13th November 2024

Application No: FP/156/24/HH
Site Address: Marine View Third Avenue Felpham PO22 7LN
Description of works: Removal and replacement of balcony to south facing elevation.

OWPC72276

Drawing Number: **5034-200** Revision: **.**

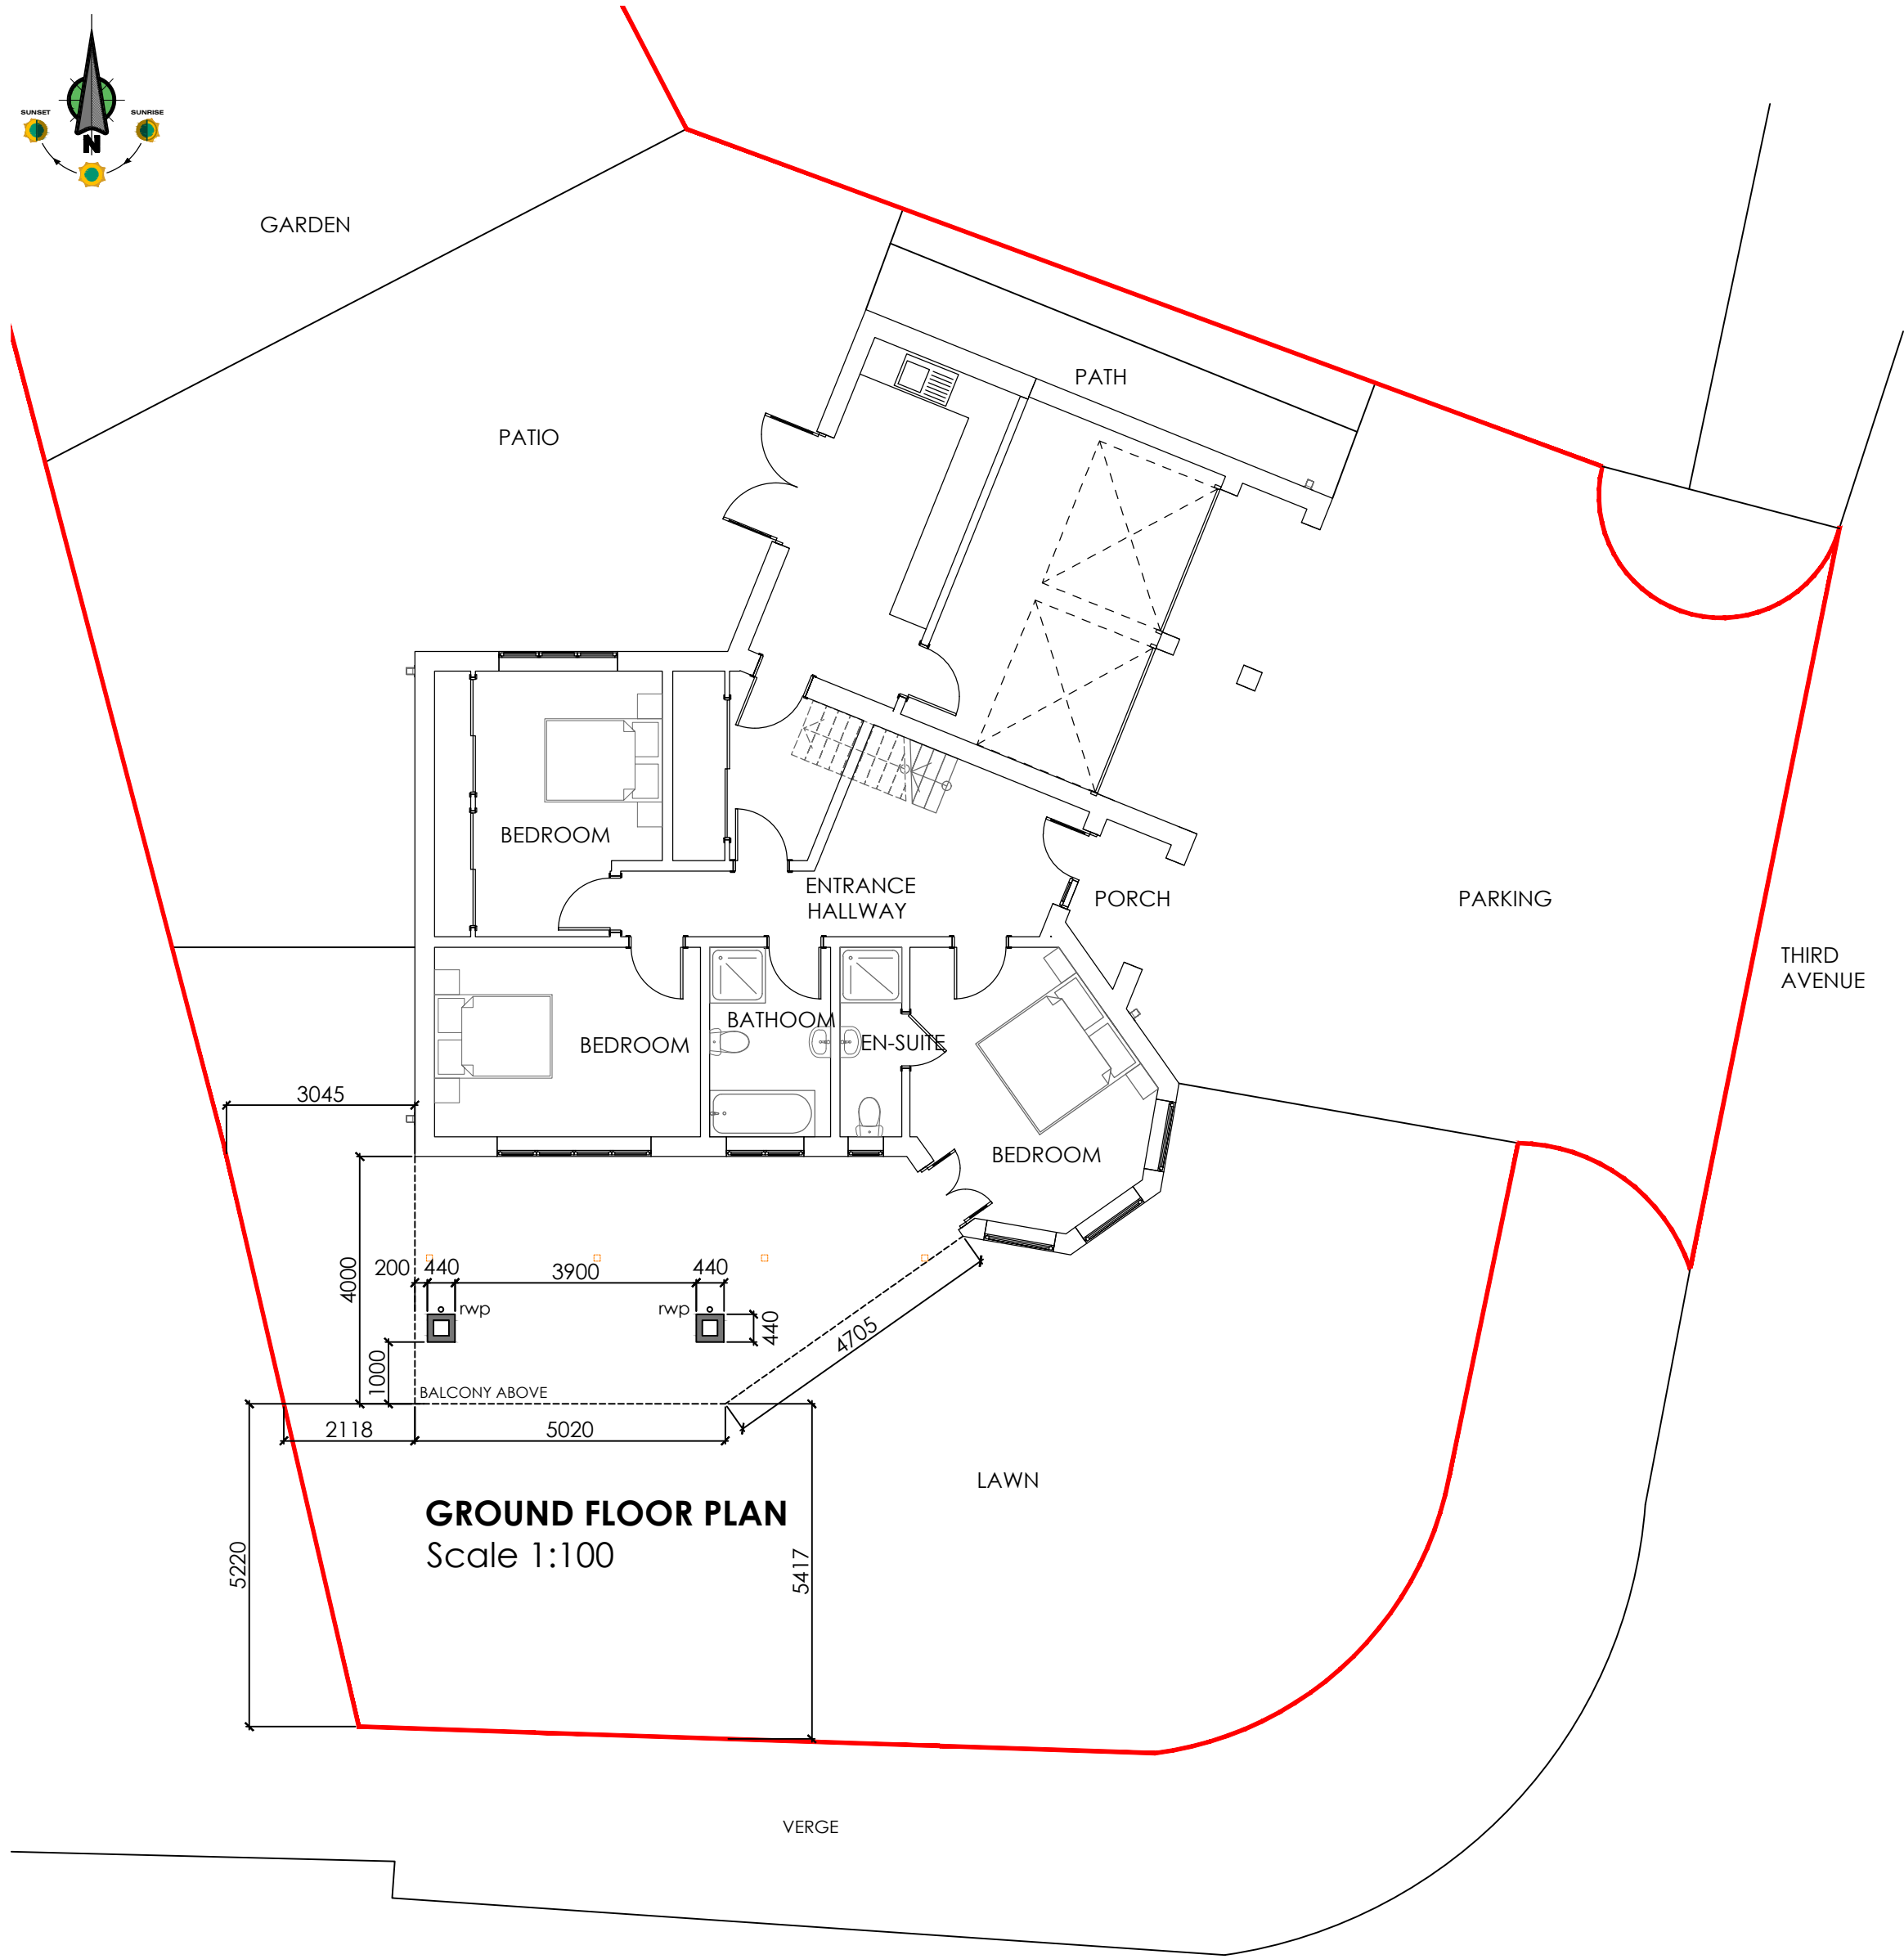
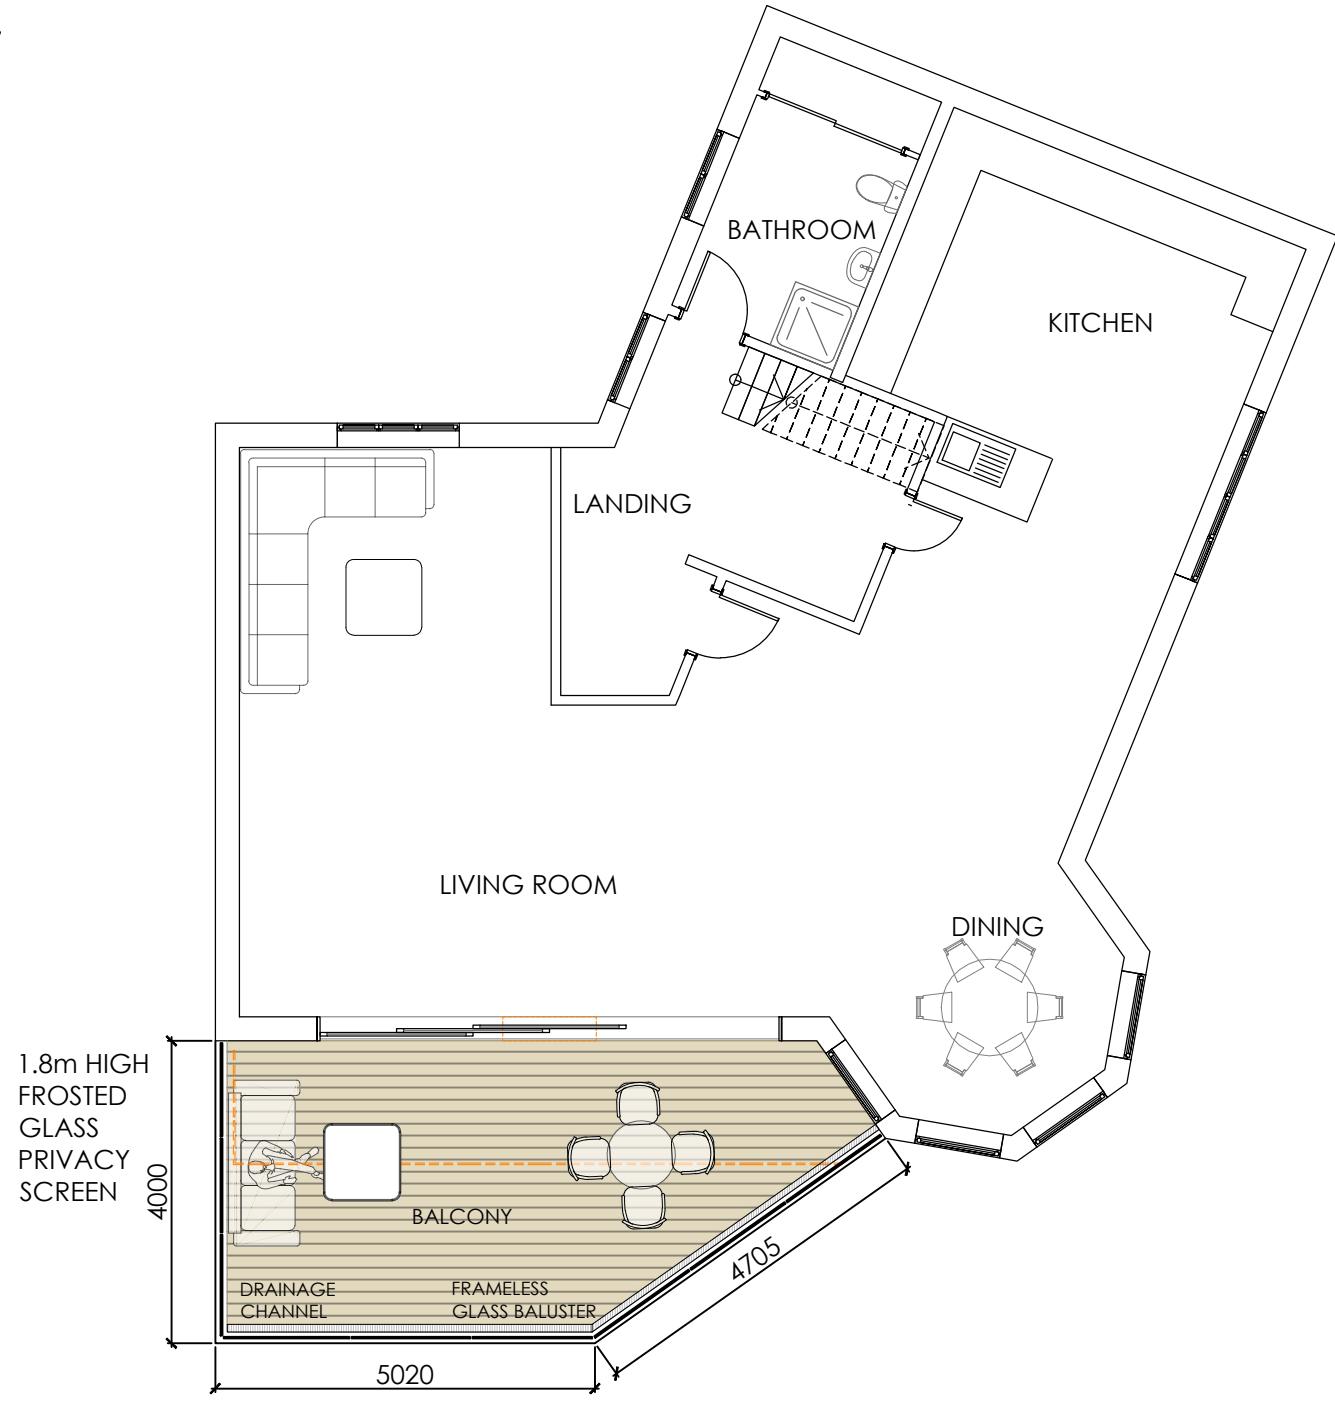
Note: Councillors query distance of balcony to boundary
